**Consultation Response from KC,
Trees**

2024/90461 Land at Occupation Road, Off Birkby Road, Birkby, Huddersfield, HD2 2ES

Erection of detached dwelling with detached garage

Date Responded: 22/03/2024

Appendix 5: Tree Constraints Plan

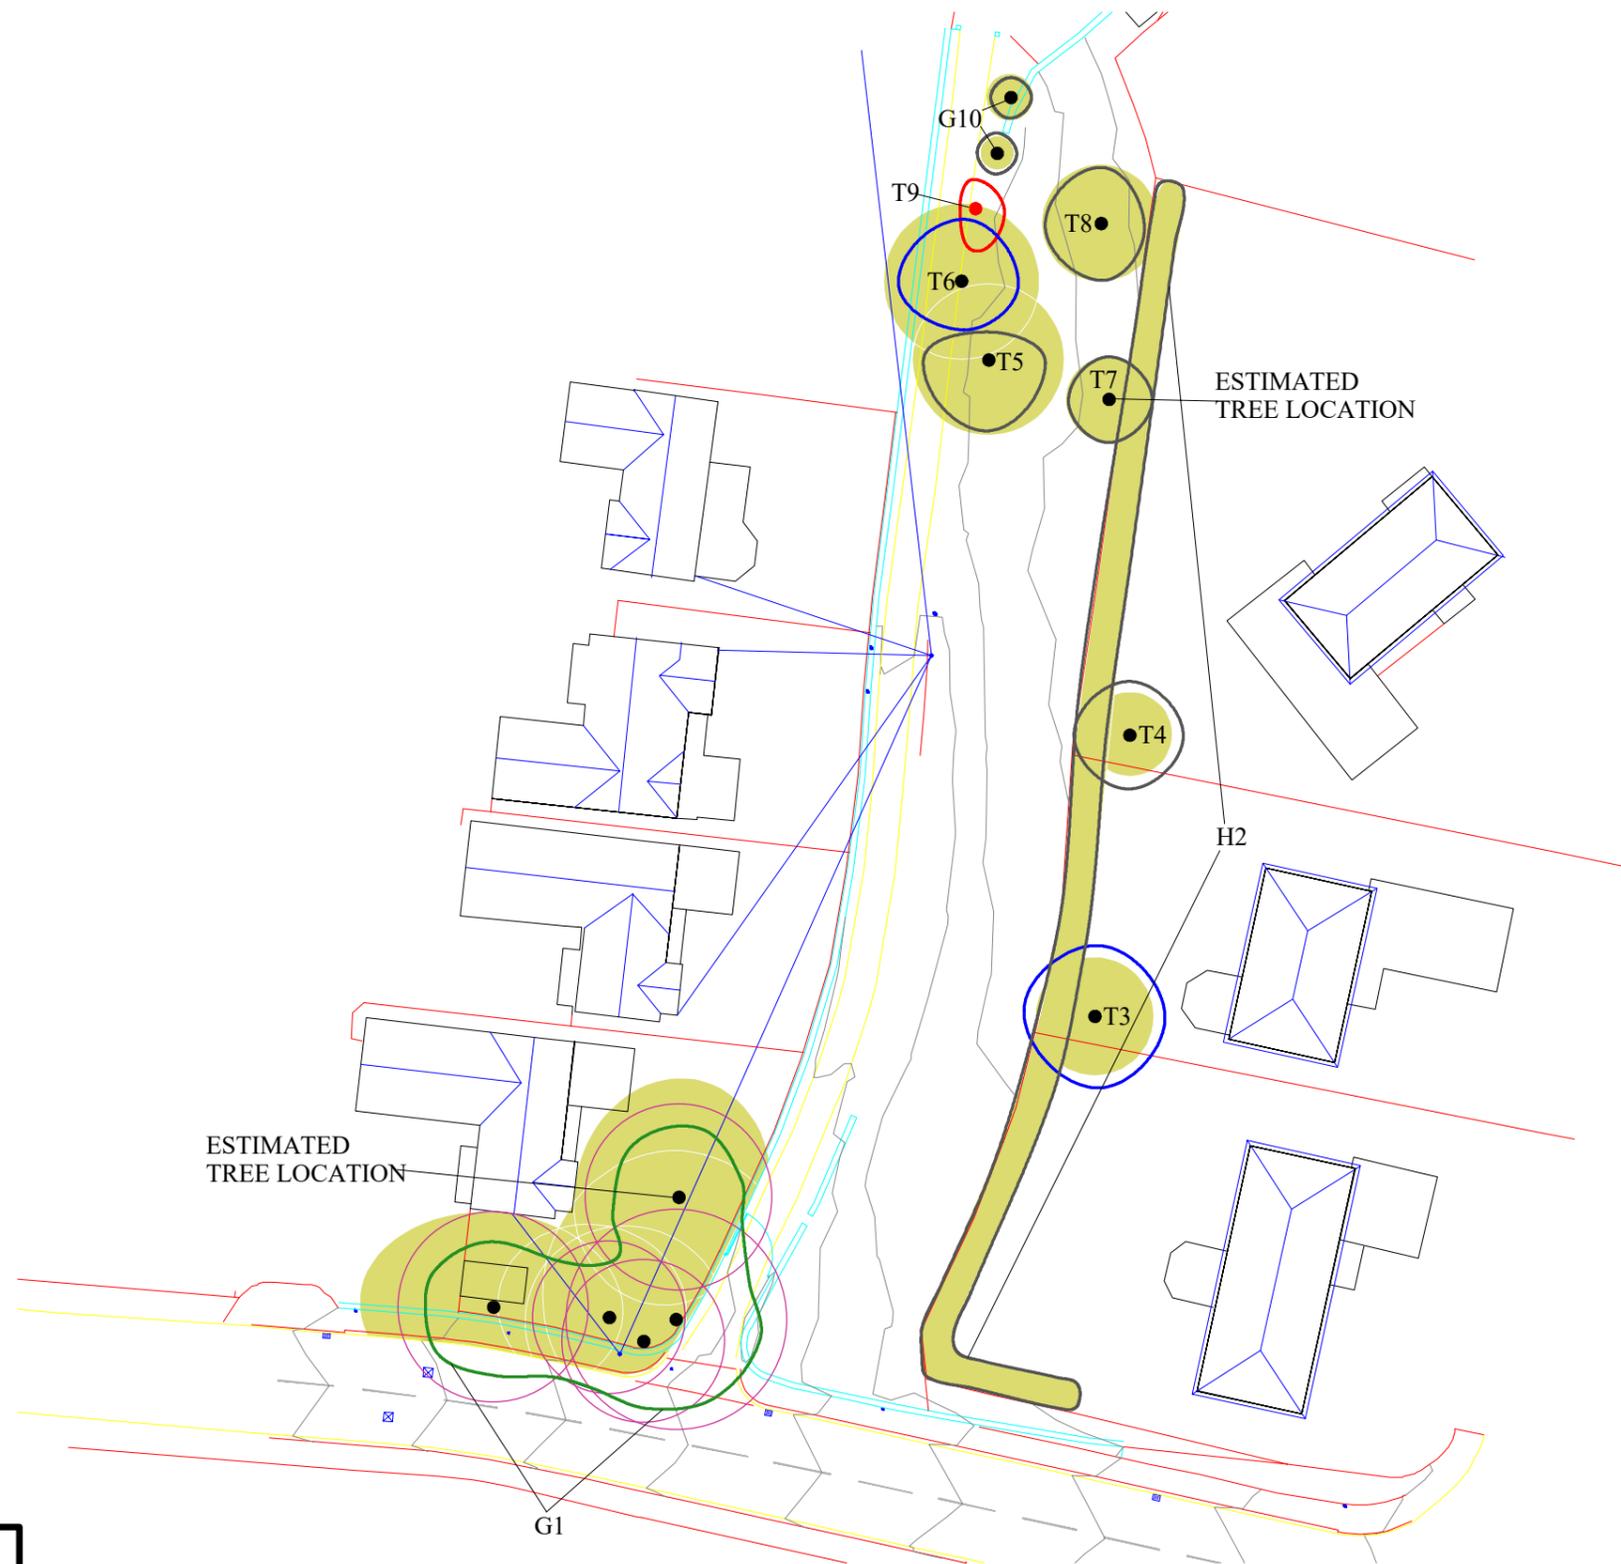
There is protected trees under TPO 31/92 adjacent to the most south westerly corner. The dwelling looks to be sufficiently located outside of the root protection area (RPA) of these trees however, the access road goes directly through the RPA's of three of these trees. There is already hardstanding in place here however the proposal shows that this will be widened directly where 31/92/t3 (Sycamore) RPA is. More clarification would be needed in regards to this access road and what methods/materials will be used for it. For example Geocellular options.

Arboricultural impact assessment is submitted to show there is no impact on the protected trees and following this an arboricultural method statement to show how the tree roots will be protected during and post construction.
